AEC/329-02

**THE NORFOLK ARMS HOTEL, ARUNDEL.
LISTED BUILDINGS CONSENT ref: AB/23/16/L
APPLICATION to DISCHARGE CONSENT CONDITION 5.**

Further to our recent e-mail correspondence, and your discussions with the Historic Buildings Officer, Dr. Ian Wightman, I can confirm that this letter is part of a formal application to discharge Condition 5 of the Listed Buildings Consent ref: AB/23/16/L, for The Norfolk Arms Hotel, Arundel.

PROPOSED  
G.A. Entrance Lobby Screens Elevations

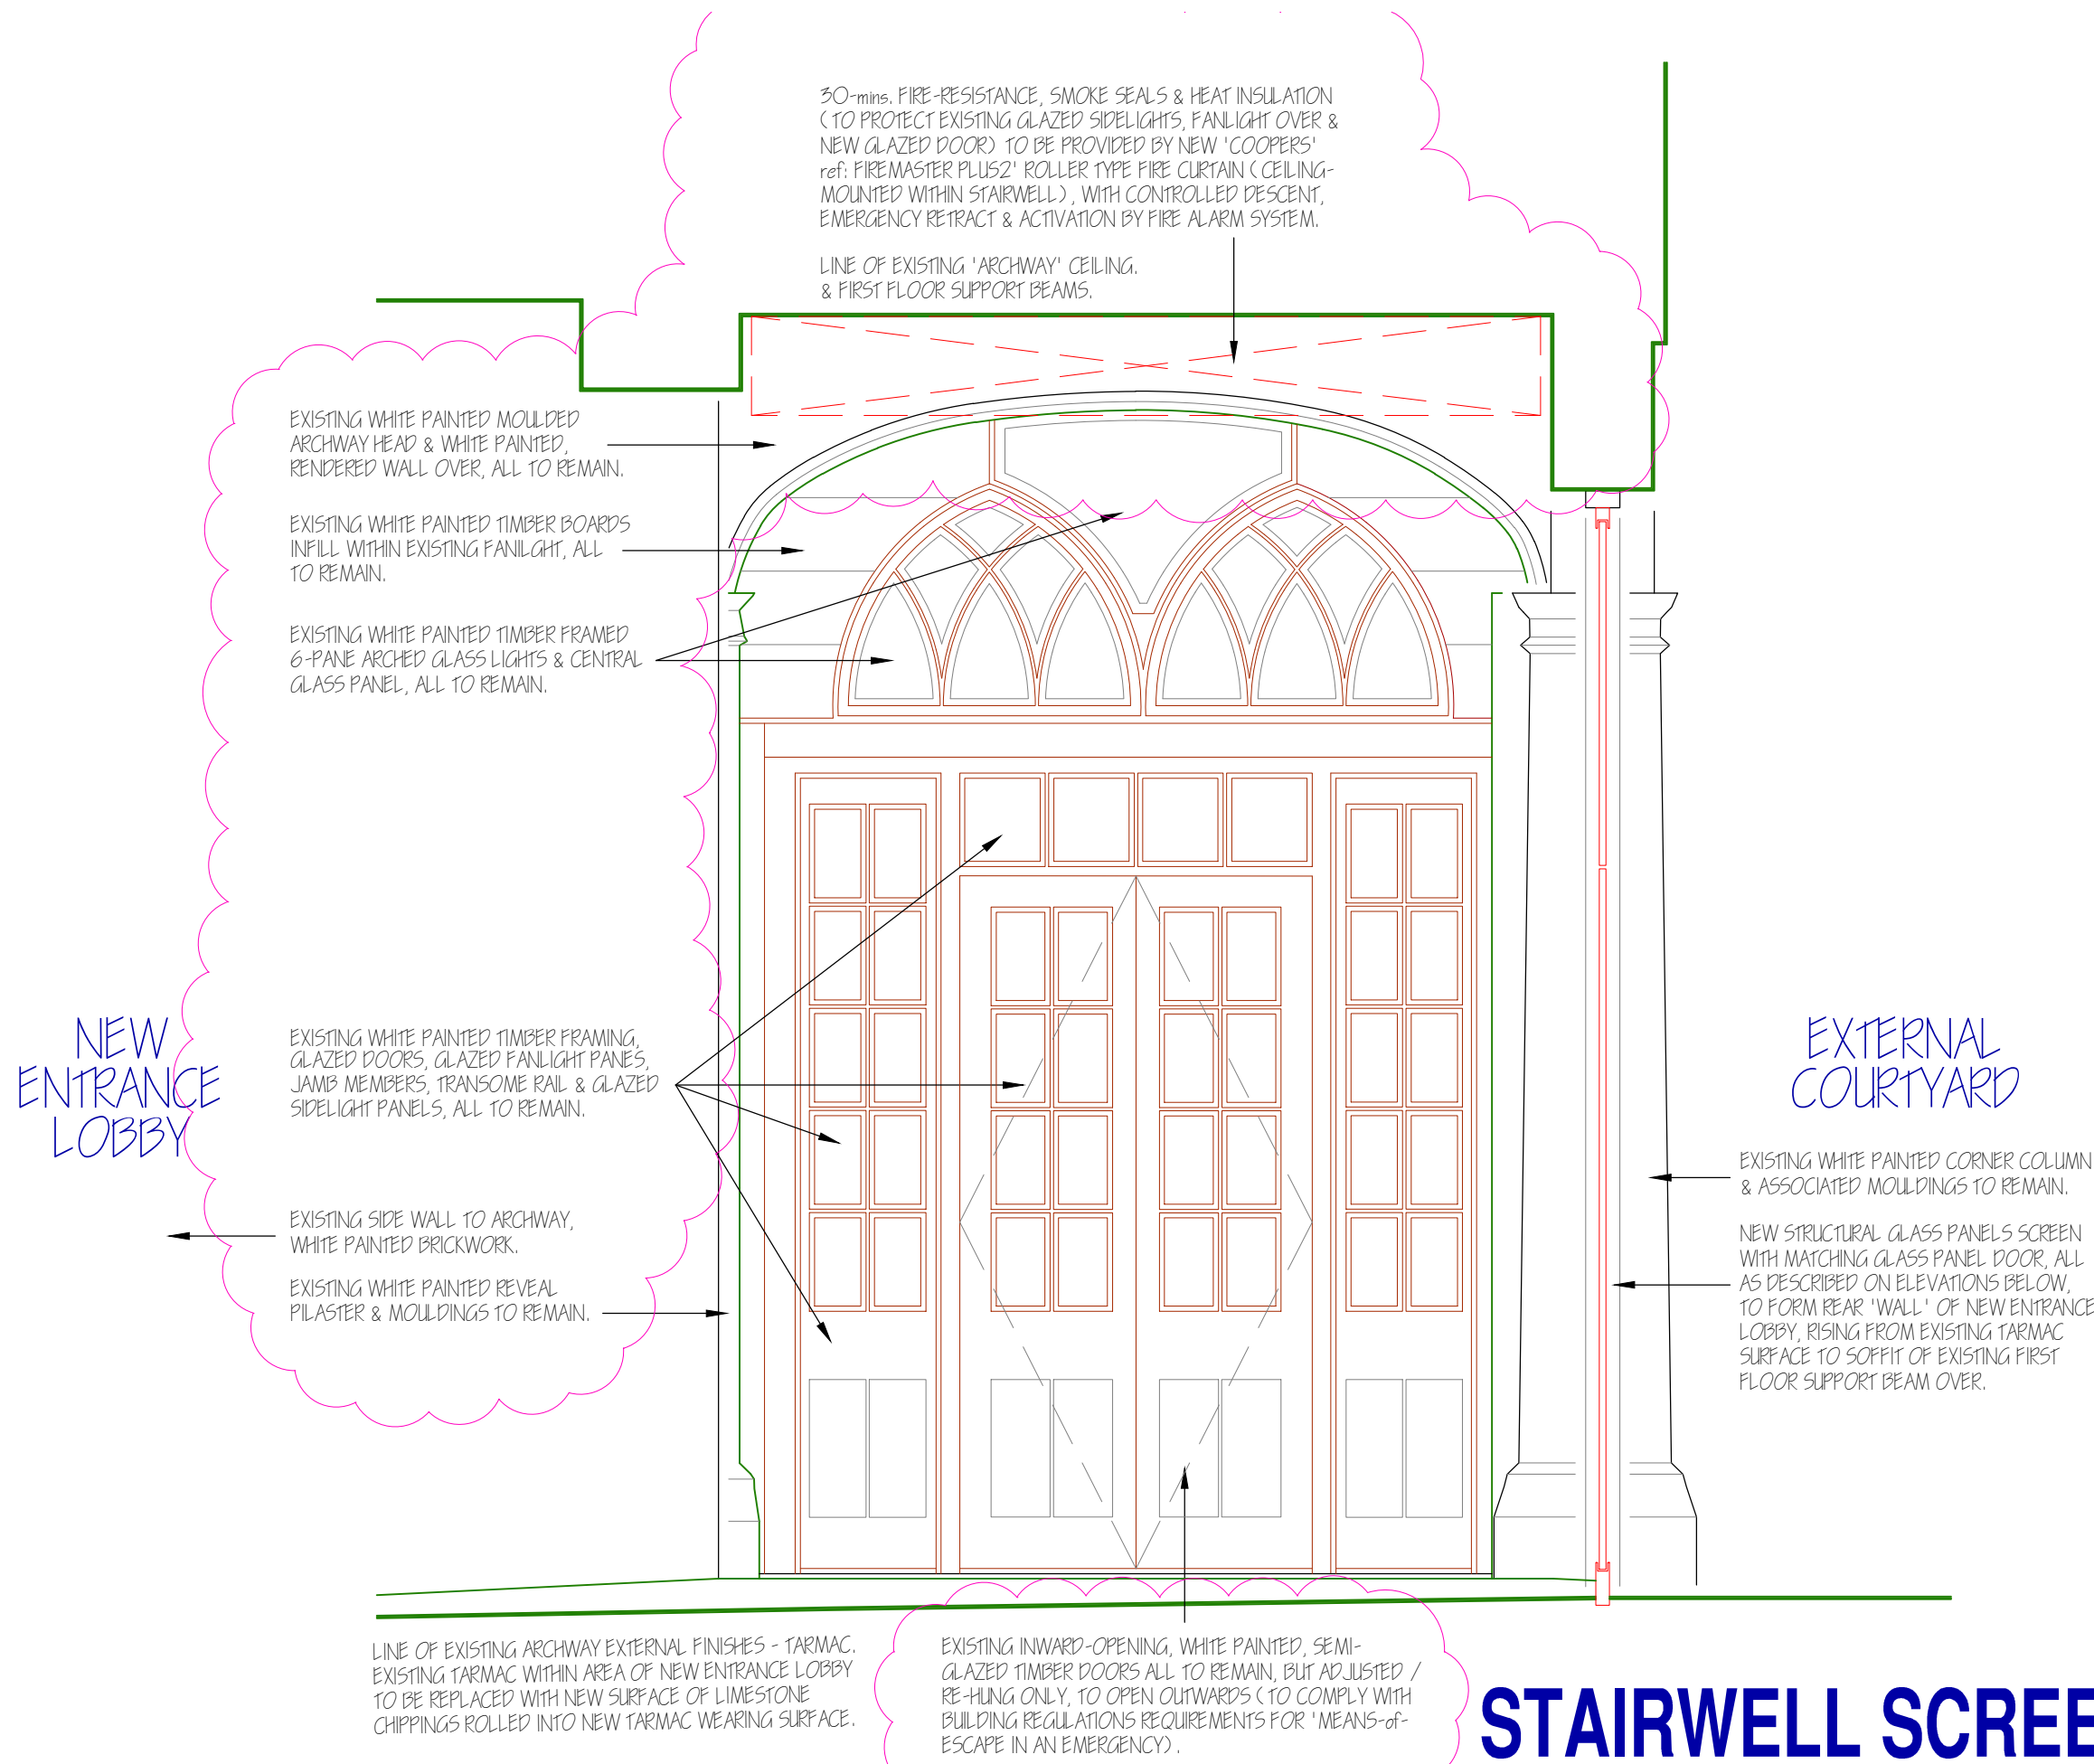
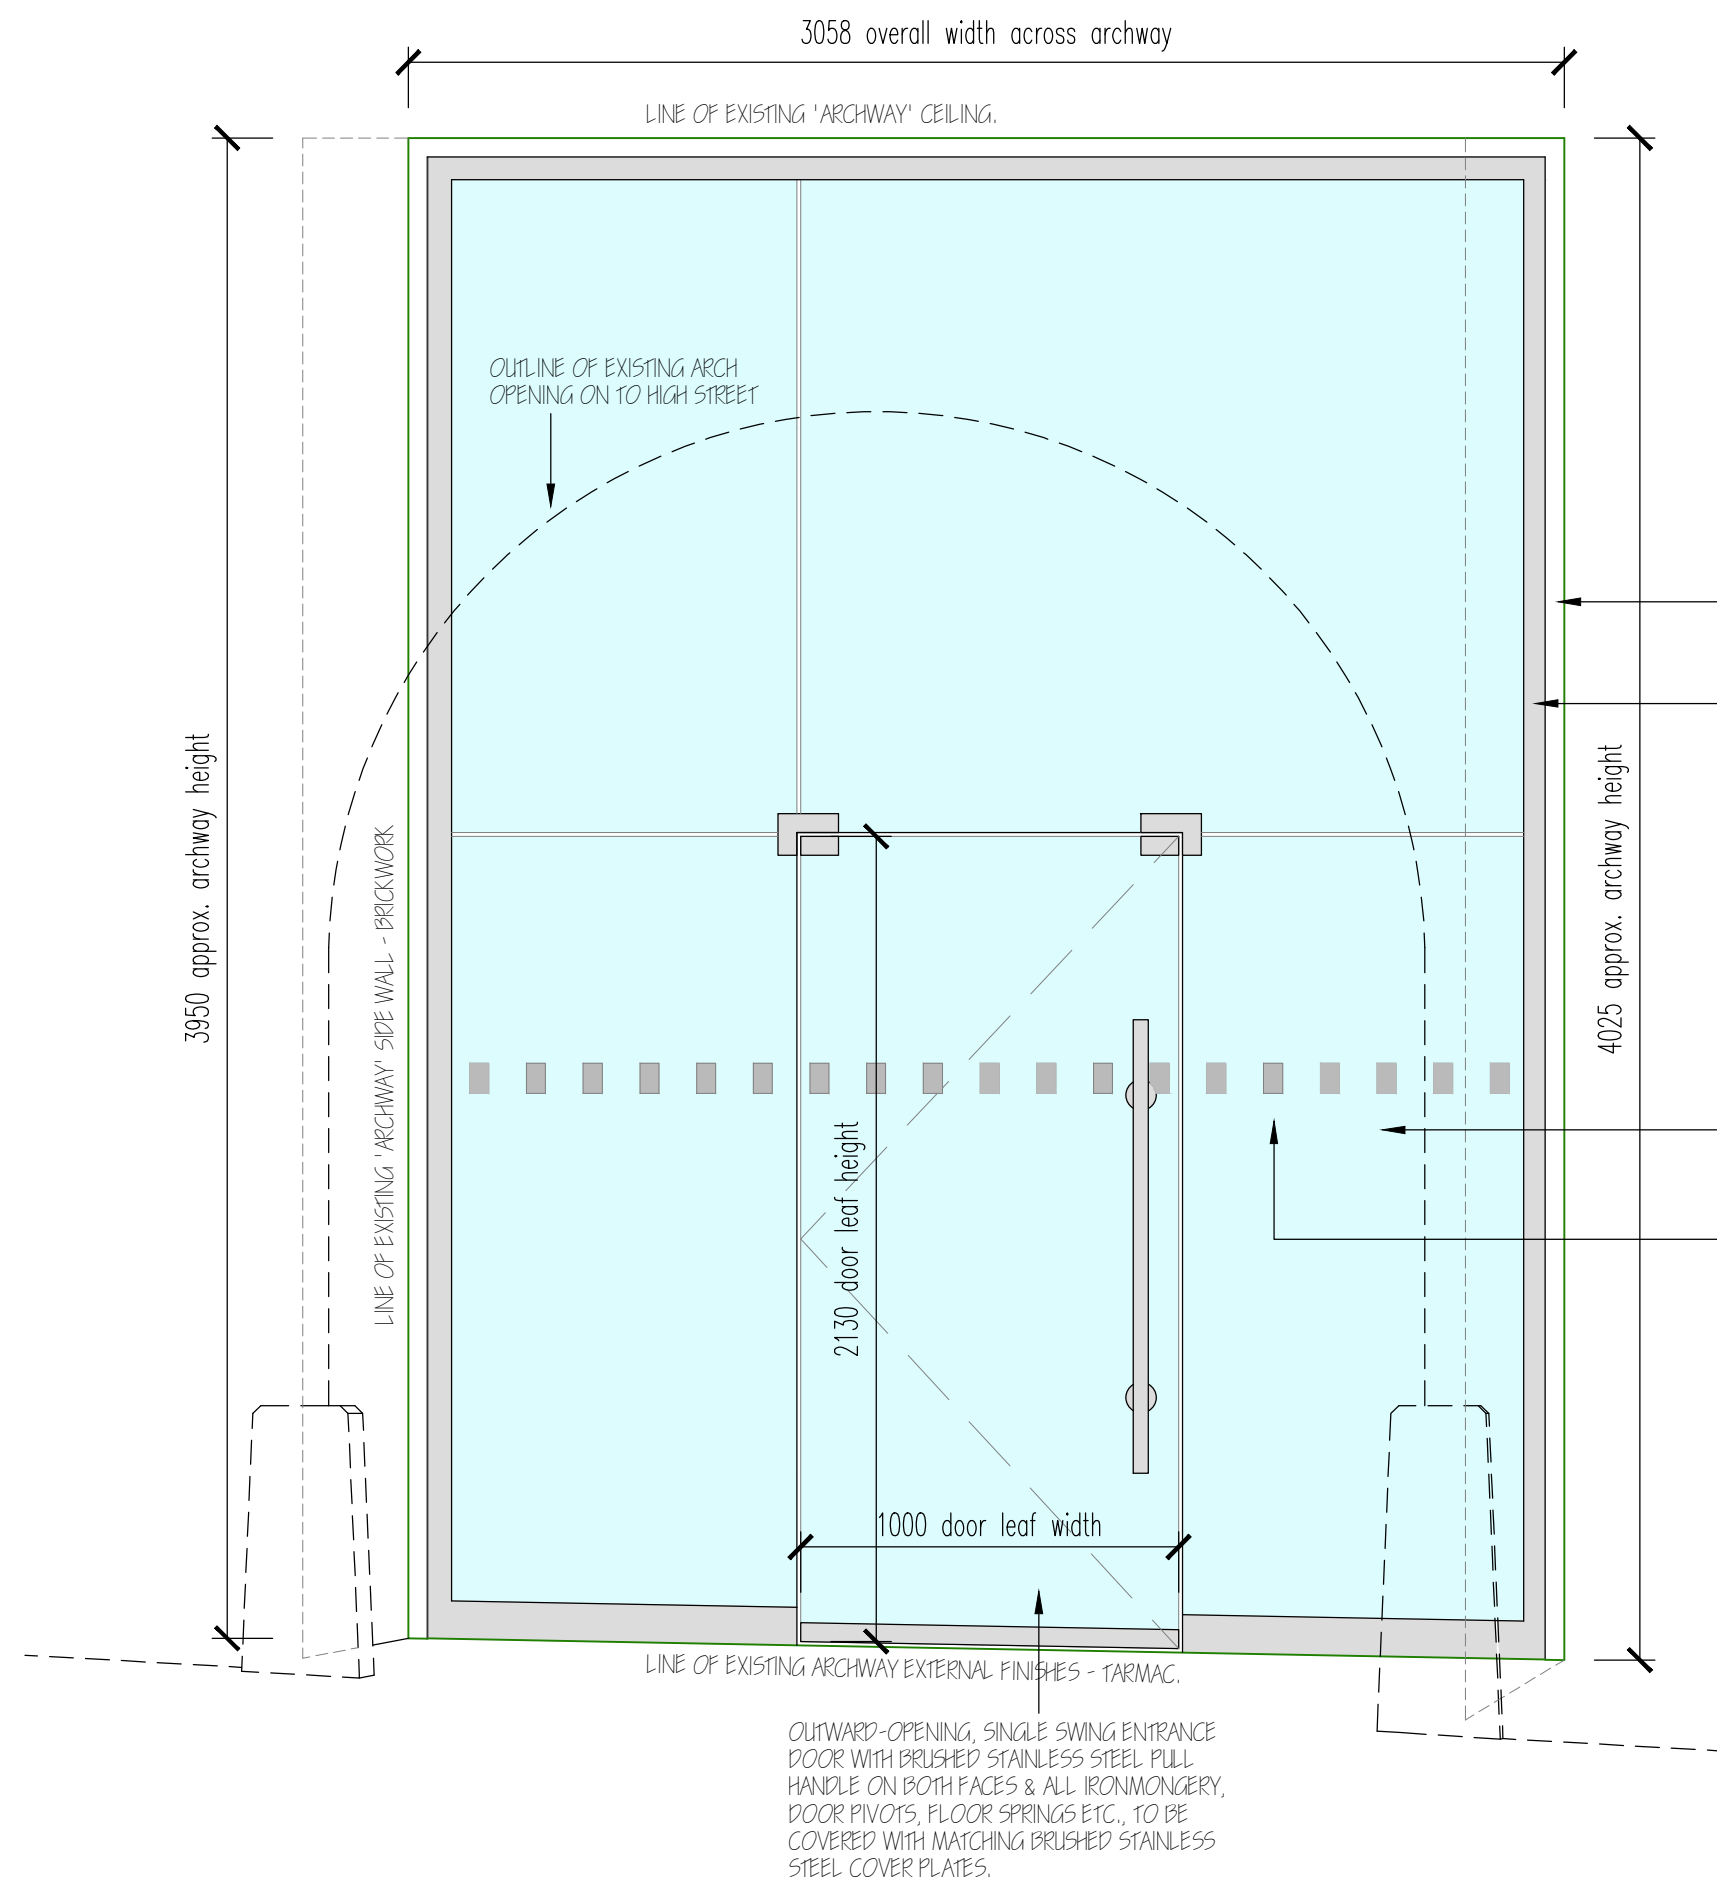
As a result, this Condition Release application proposes the installation instead, of 2no. ceiling-mounted 'fire curtains' within the Reception Corridor and rear Stairwell, which would enable the existing Reception entrance door & fanlight and the existing Stairwell glazed screen, glazed doors & fanlight etc. to be fully retained and unaffected.

Dr. Wightman was previously concerned also that the existing pair of glazed doors within the Stairwell glazed screen should not be replaced. The application drawings now show the existing pair of doors being retained and unaltered, except that they would need to be re-hung to open outwards, in the direction of emergency escape.

Under current Building Regulations, there is a requirement for '... the door of any doorway or exit should, if reasonably practicable, be hung to open in the direction of escape and should always do so if the number of persons that might be expected to use the door at the time of a fire is more than 60' (Building Regs. Part B, Vol.2, para 5.14).

The occupancy numbers of the Hotel guests and staff means that these doors would fall into the 'more than 60' category, hence the need to re-hang the existing door leaves within the existing frame.
